CM/49/21/DOC

Kents Farm House Brookpit Lane Climping BN17 5QU

Approval of details reserved by condition imposed under ref CM/51/20/L relating to Condition Nos - materials and finishes, 2 - handrails and balusters and 3 - information regarding walls of light well and any safety features.

Drawing Title
**1st TO 2nd FLOOR
STAIRCASE DETAILS**

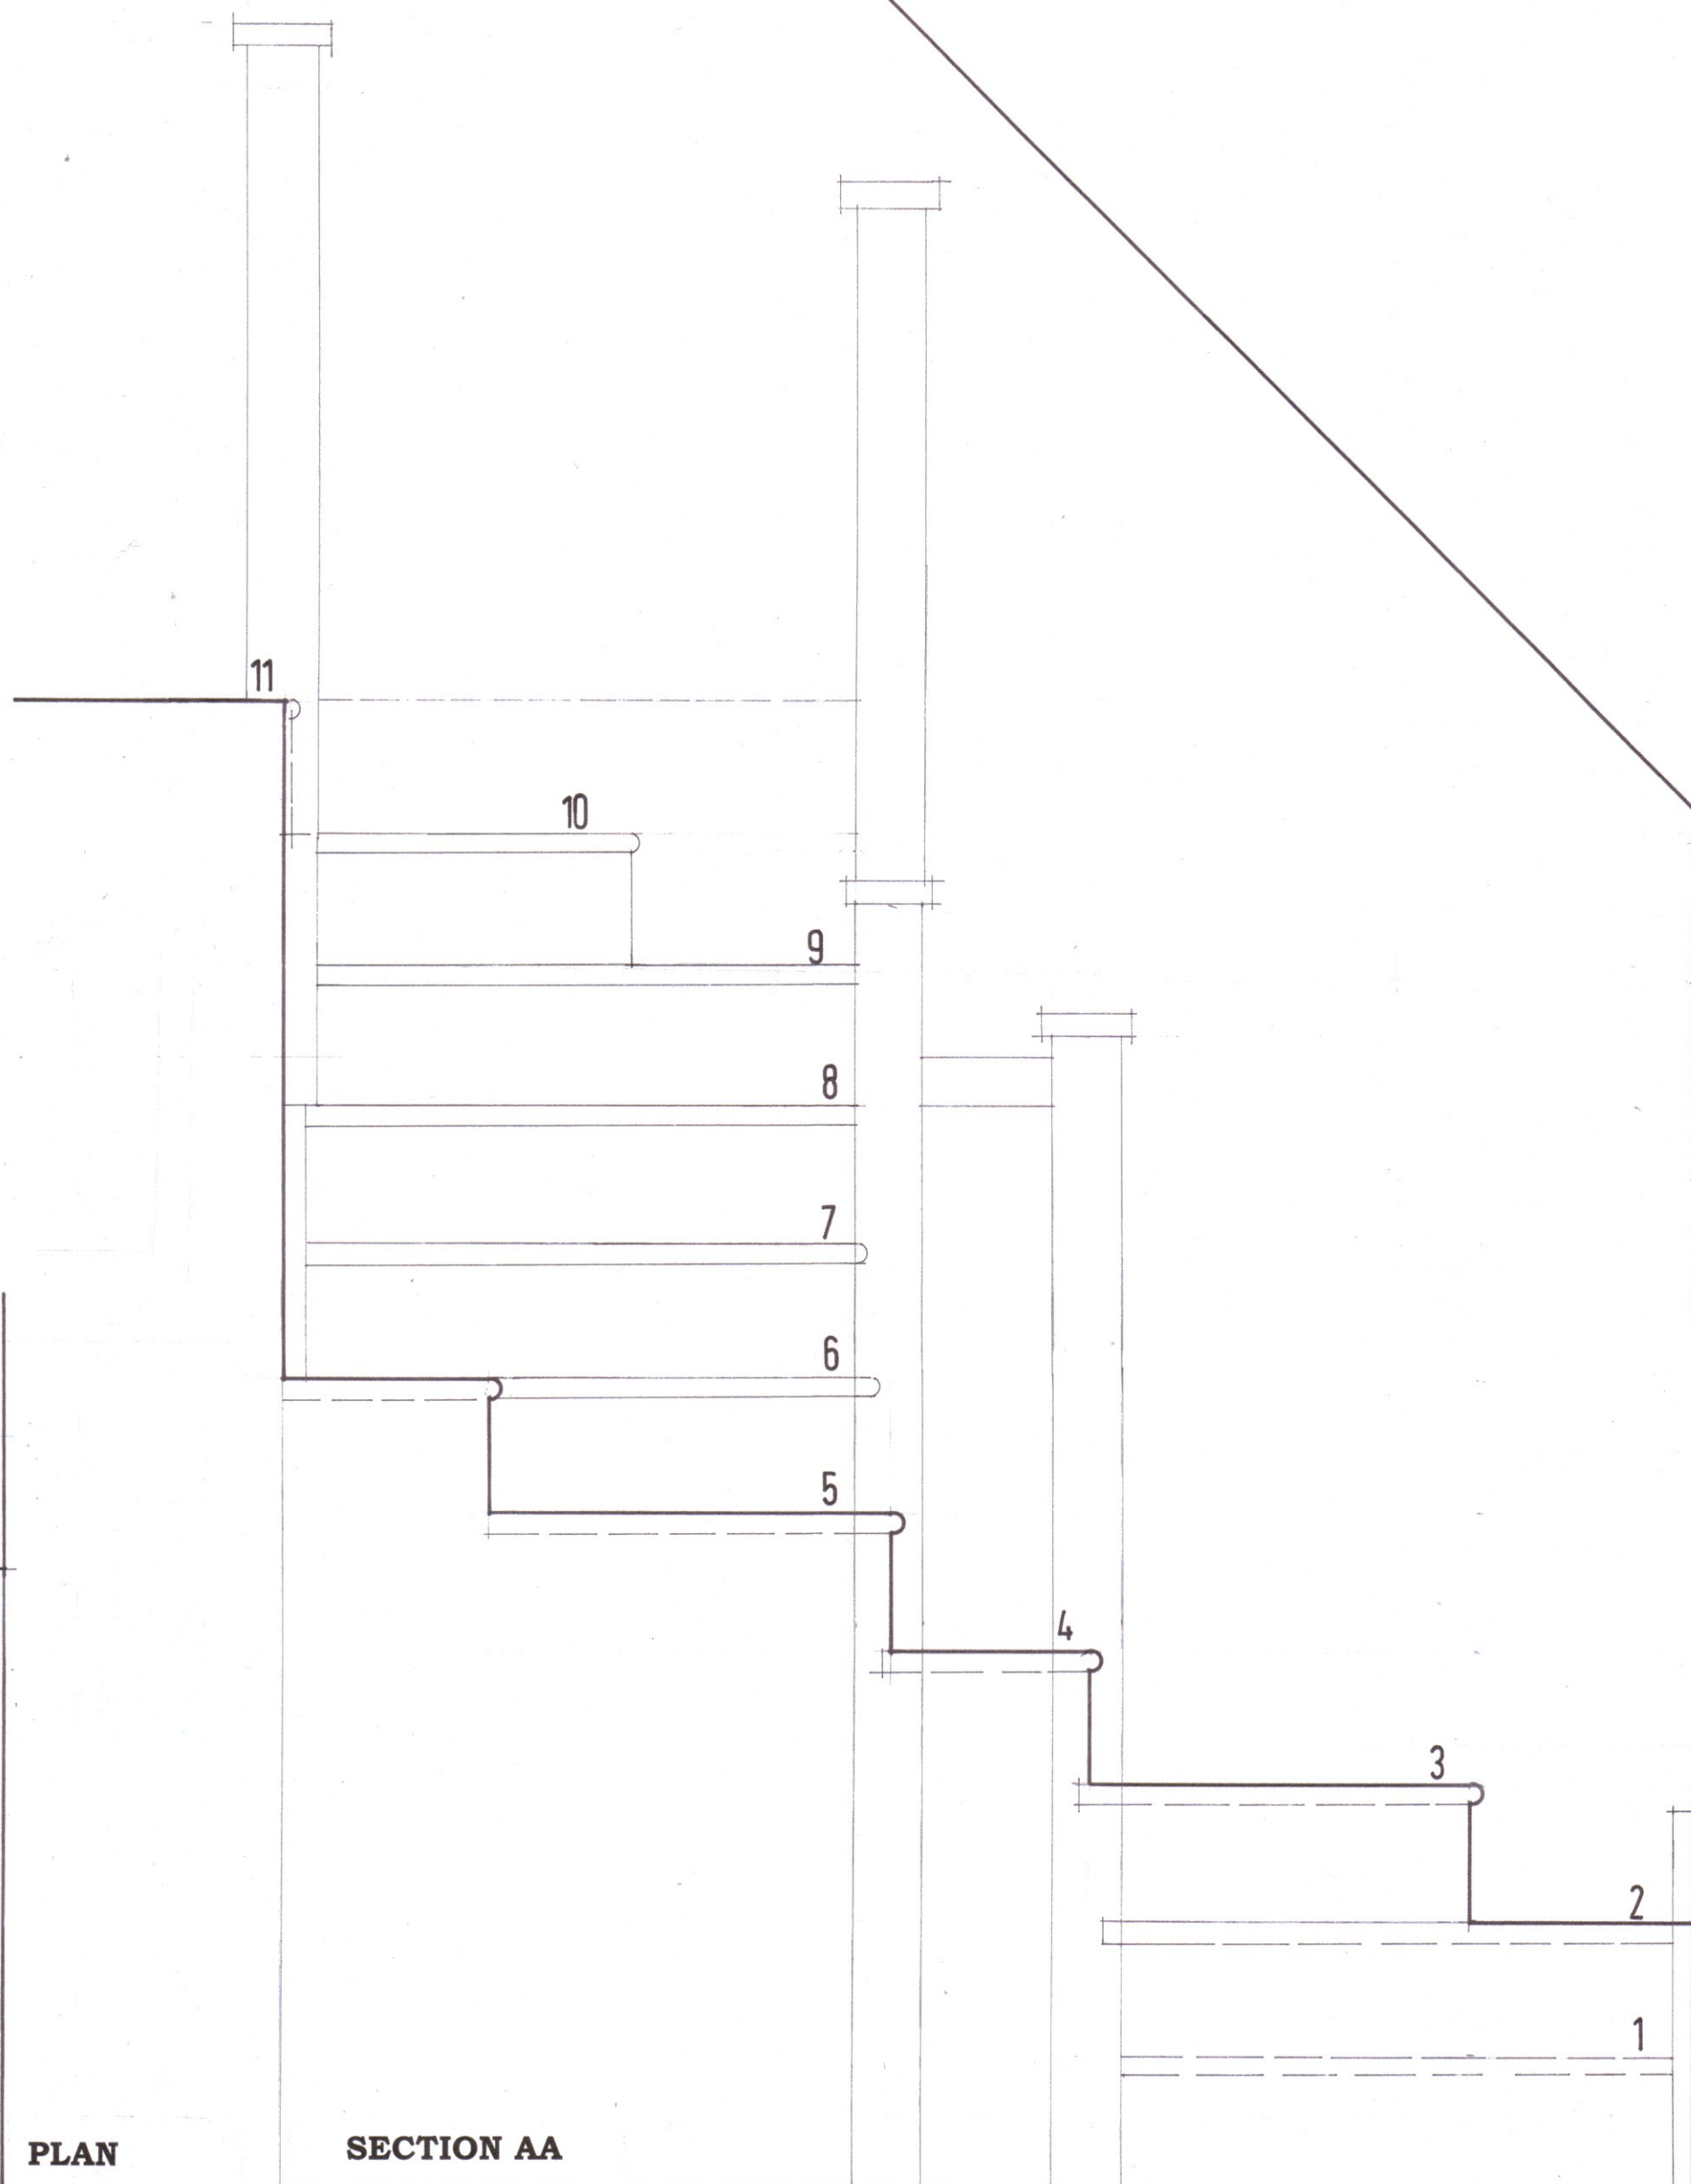
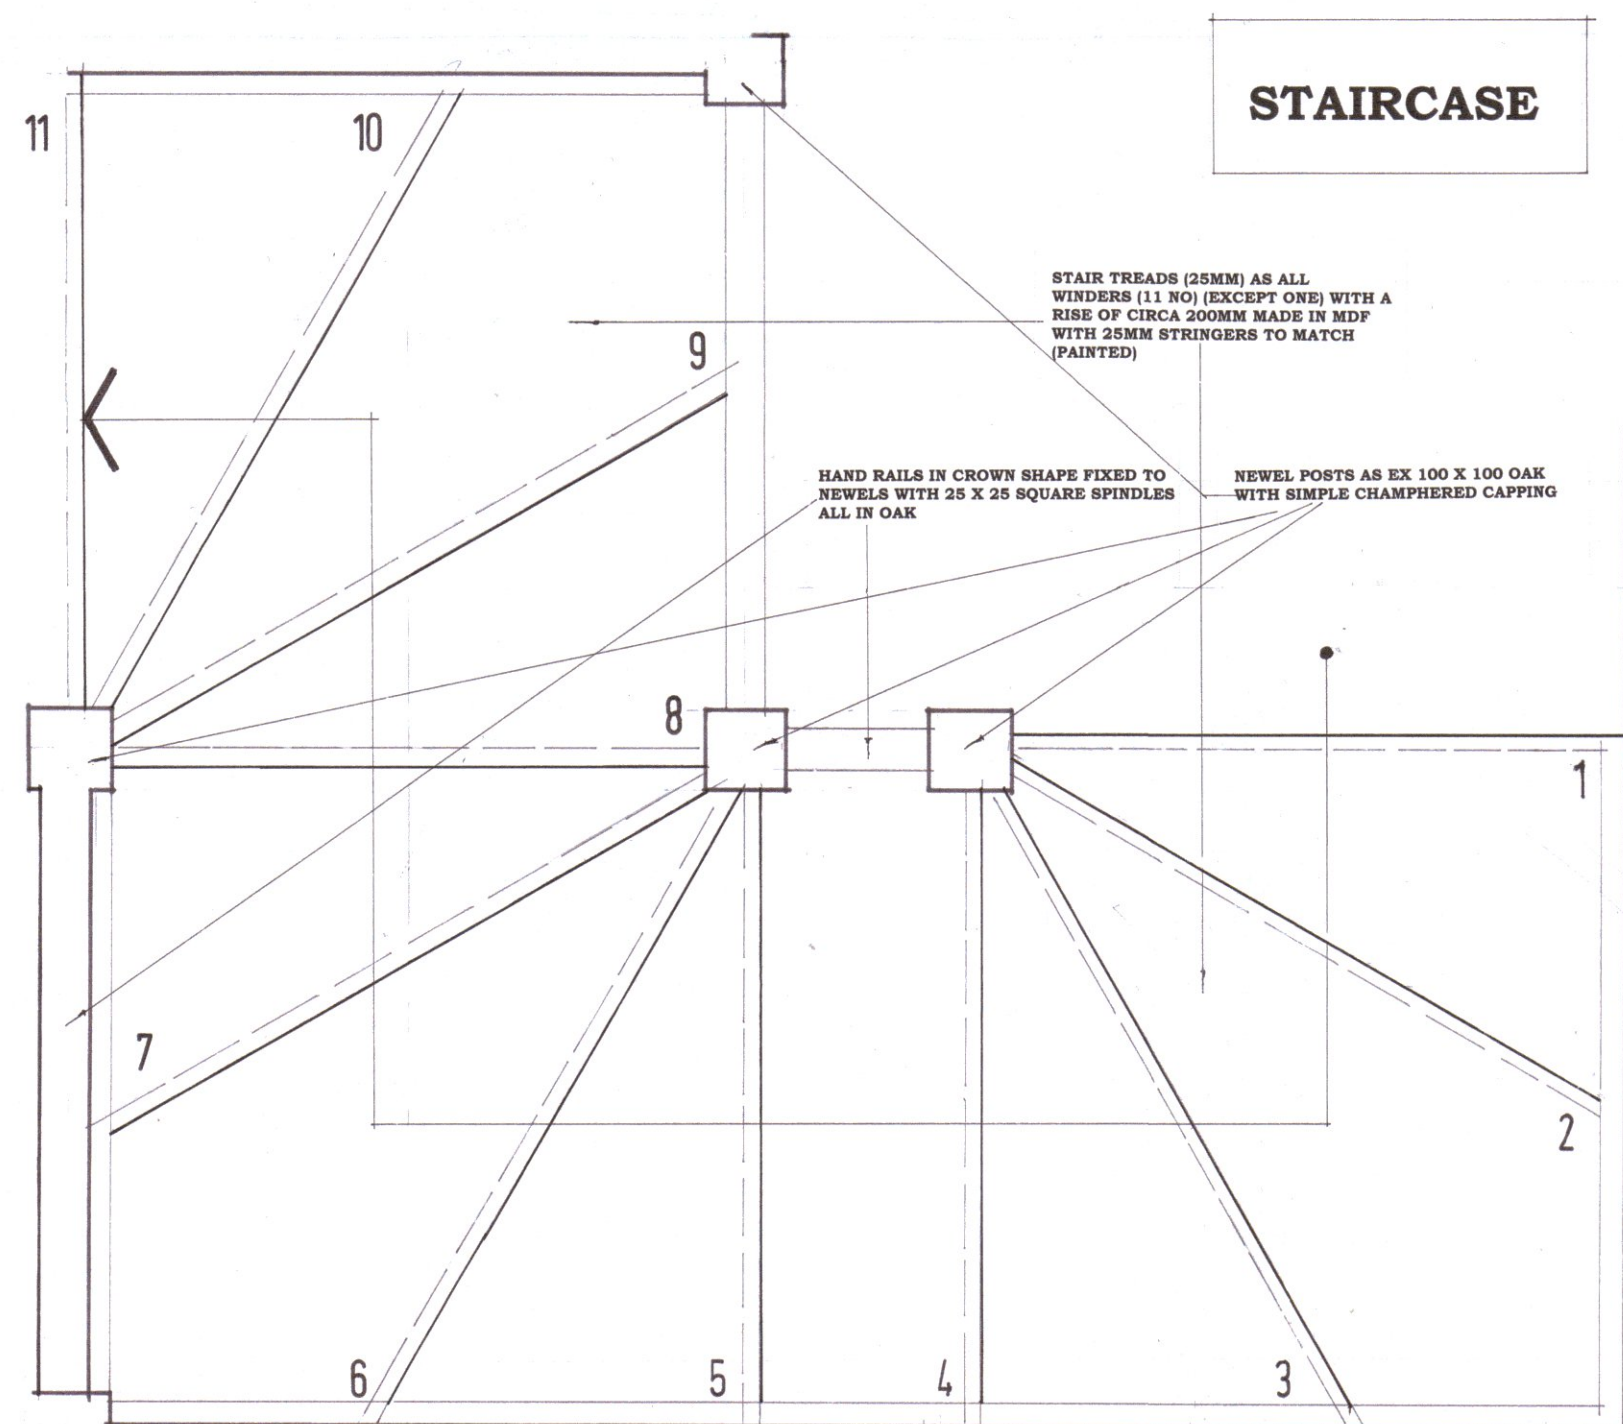
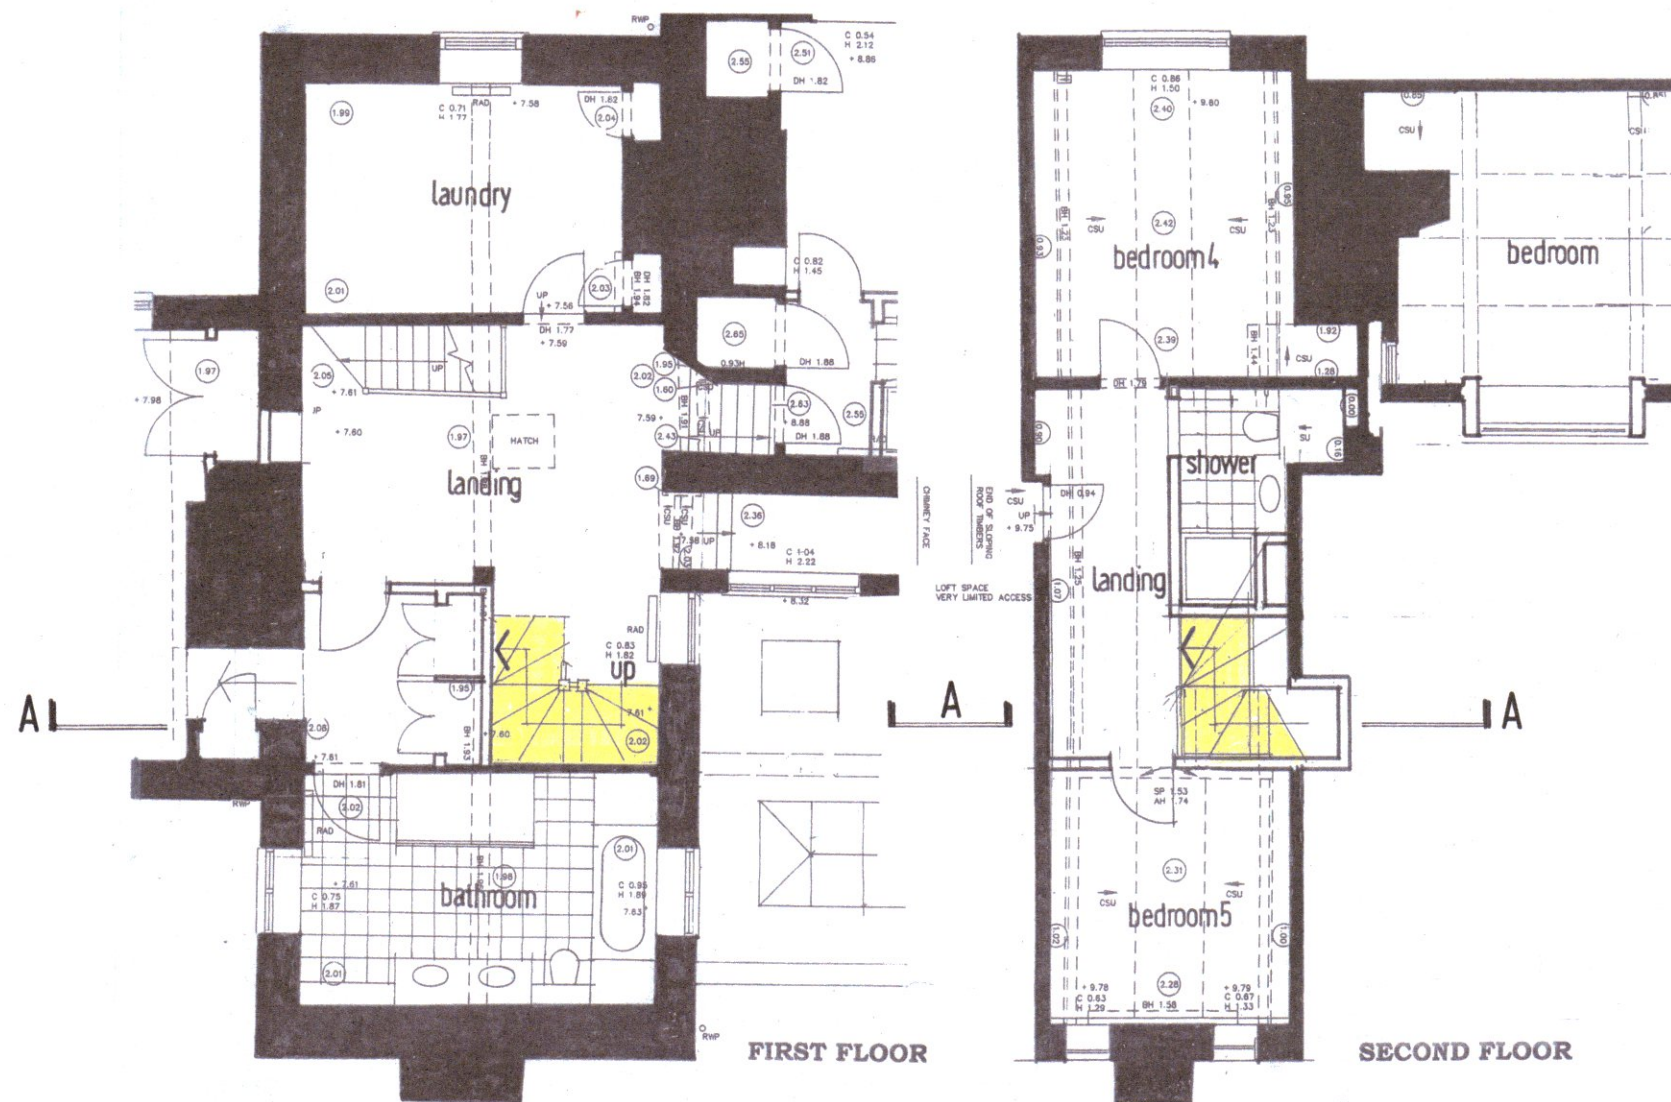
Condition 2 - The details are acceptable, and the condition can be discharged.

< ^{1/11} > **Roof Lanterns and** **Pyramid Rooflights** **x**

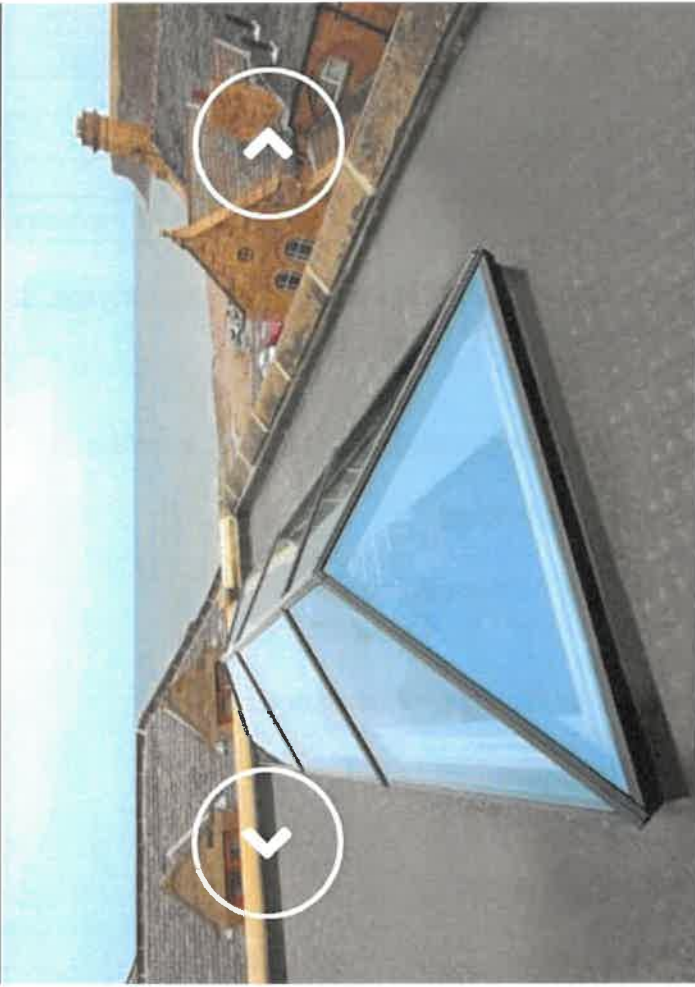
Condition 3 – if the walls of the lightwell follow the specification identified in the schedule of materials and finishes document (under the header of 'walls'), this is acceptable. However, it is not clear if any safety features are to be added to the light well, as these do not appear to have been supplied as part of this application.
